We have the following comments regarding conditions 21 and 22.

Condition 21- surface water drainage design

Laura Gibbons

Engineer, Adur & Worthing Councils

TITLE
Proposed Drainage Strategy

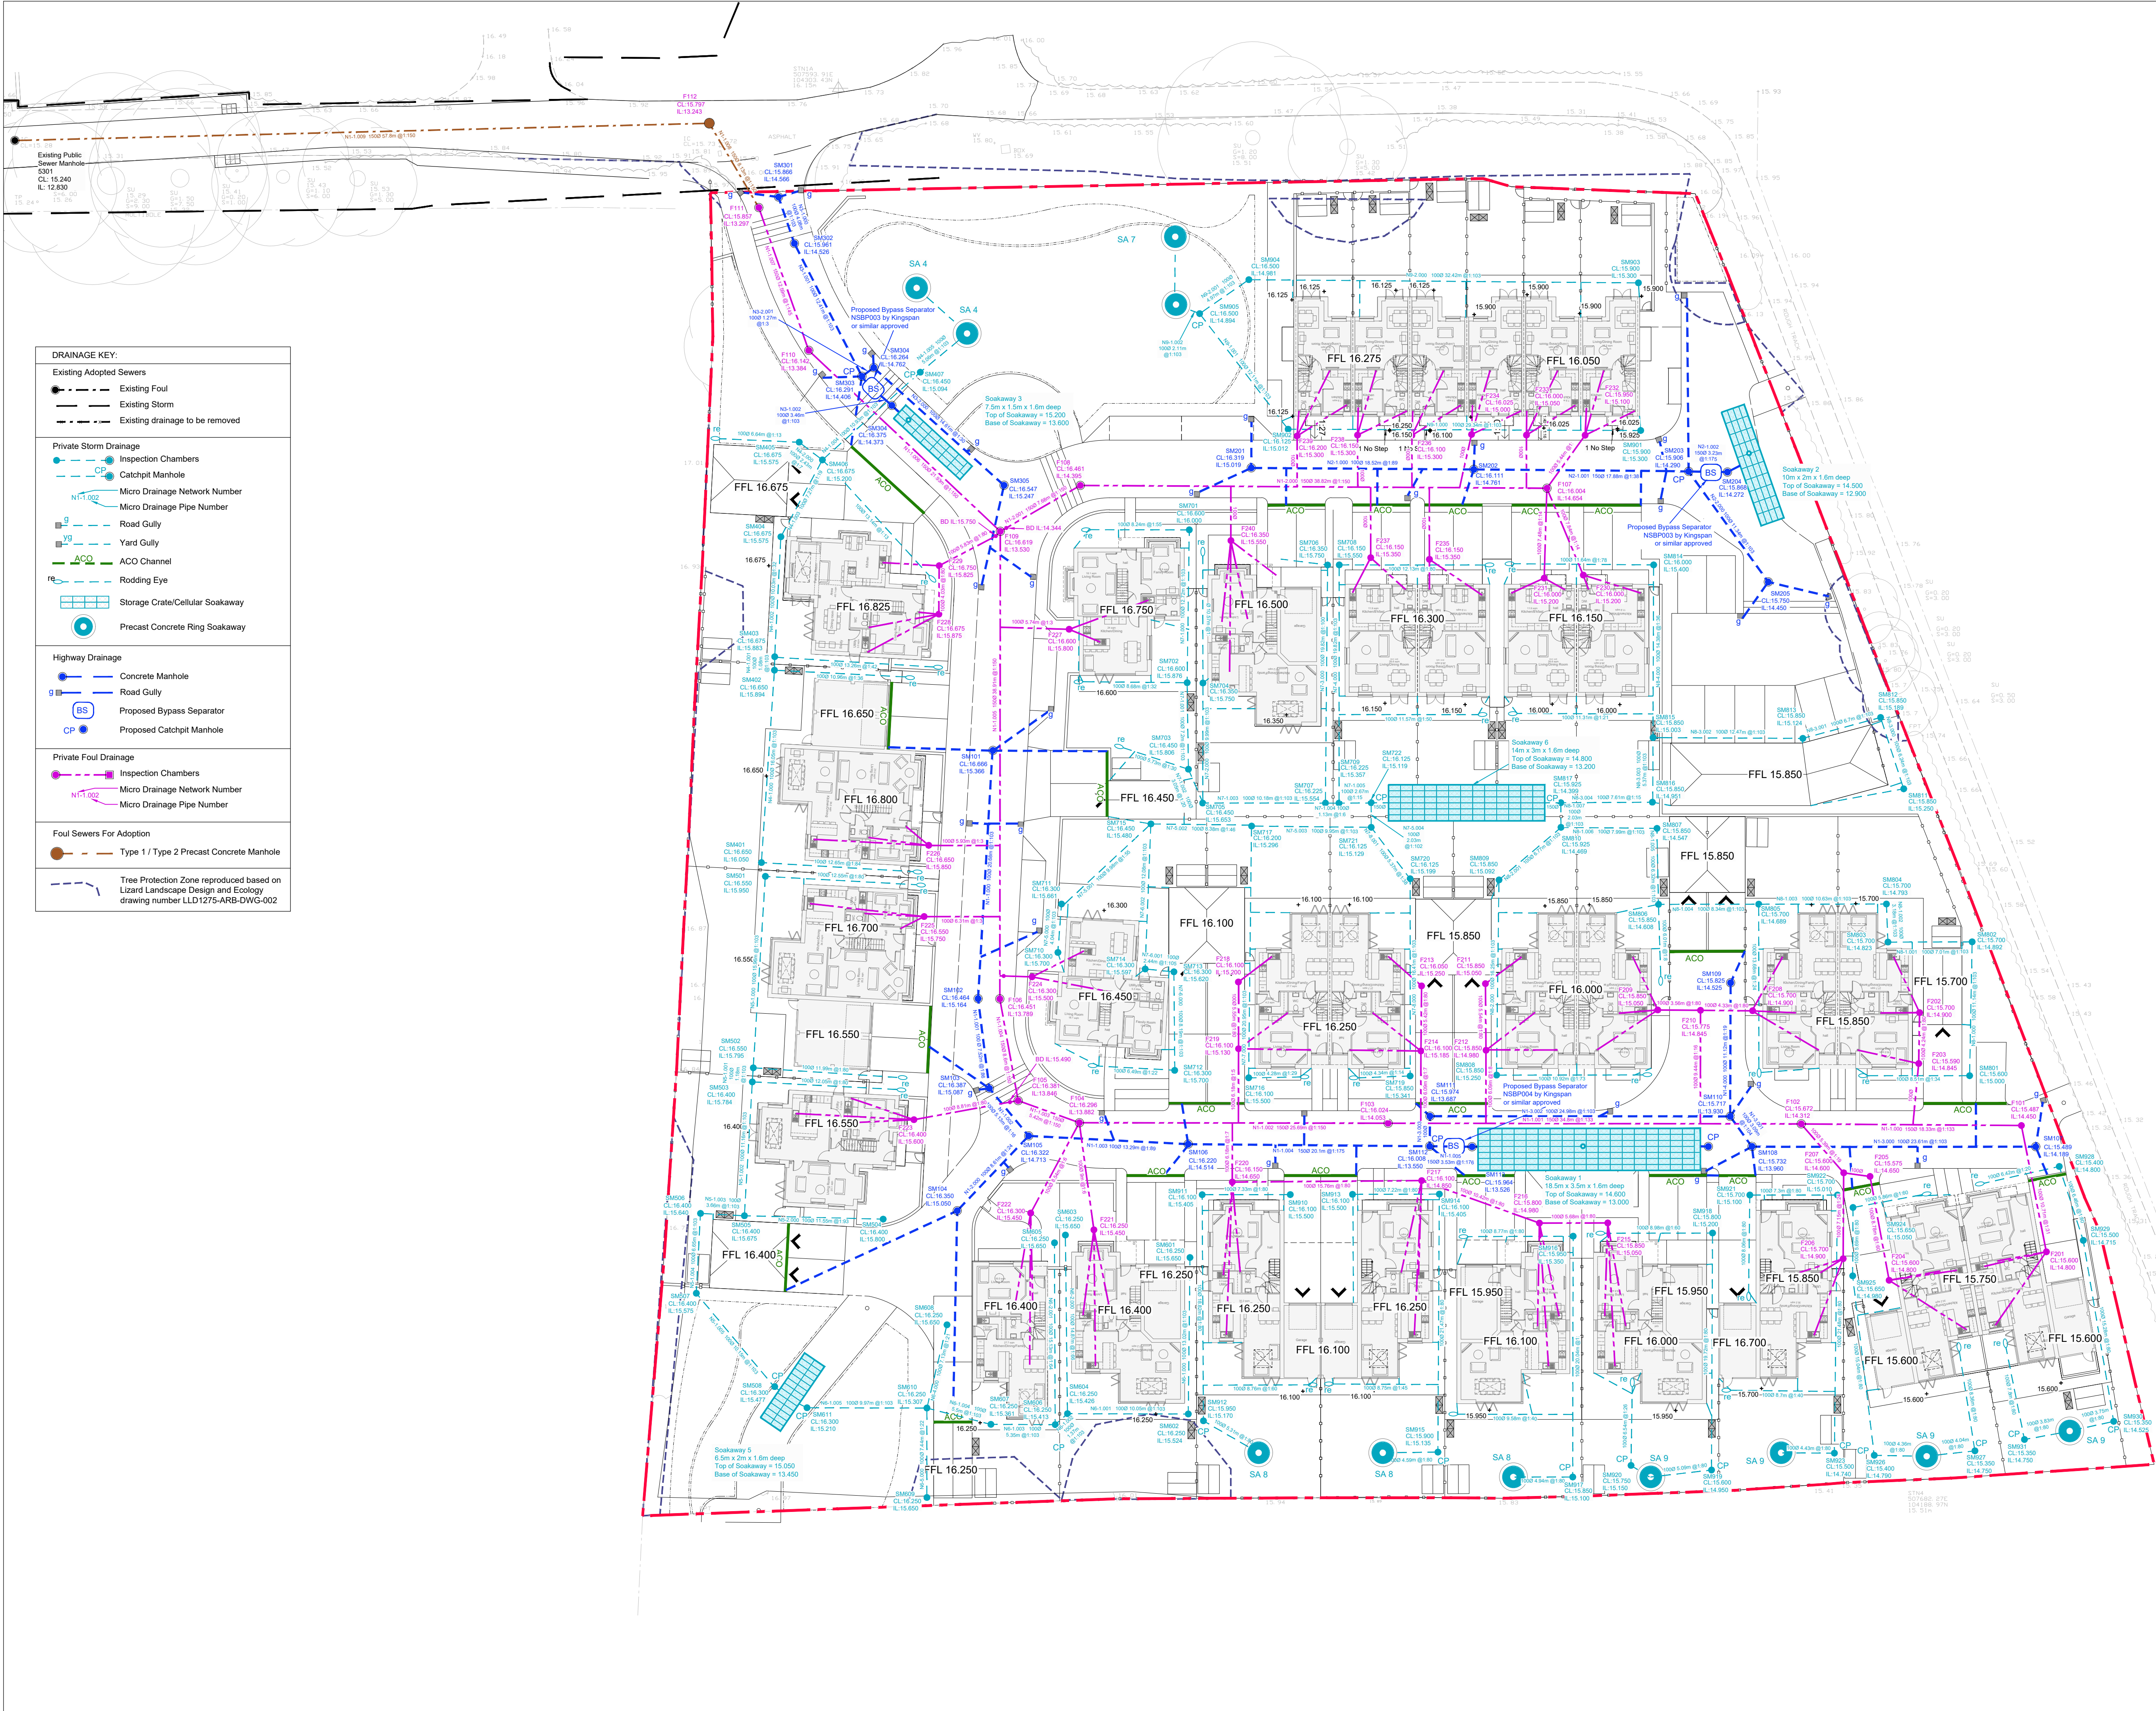
1. Ground water monitoring was undertaken at only two locations on site, and was not undertaken for the entire winter period as outlined in the condition. It is deemed that the level of data presented is insufficient.
2. Infiltration testing was undertaken in June. Winter infiltration testing must be undertaken. All infiltration tests were undertaken at circa 2.5m depth, yet some of the soakaways are considerably shallower than this.

It is not possible to review the robustness of design without this information. Design must be evidenced to have surface water features above peak seasonal groundwater levels, and design must be based on winter infiltration rates to ensure it is able to cope with seasonably lower permeability. This is important to ensure flood risk is not increased as a result of development.

Unless further winter groundwater monitoring and winter infiltration testing is submitted we would recommend refusal of the application to discharge conditions 21 and 22.
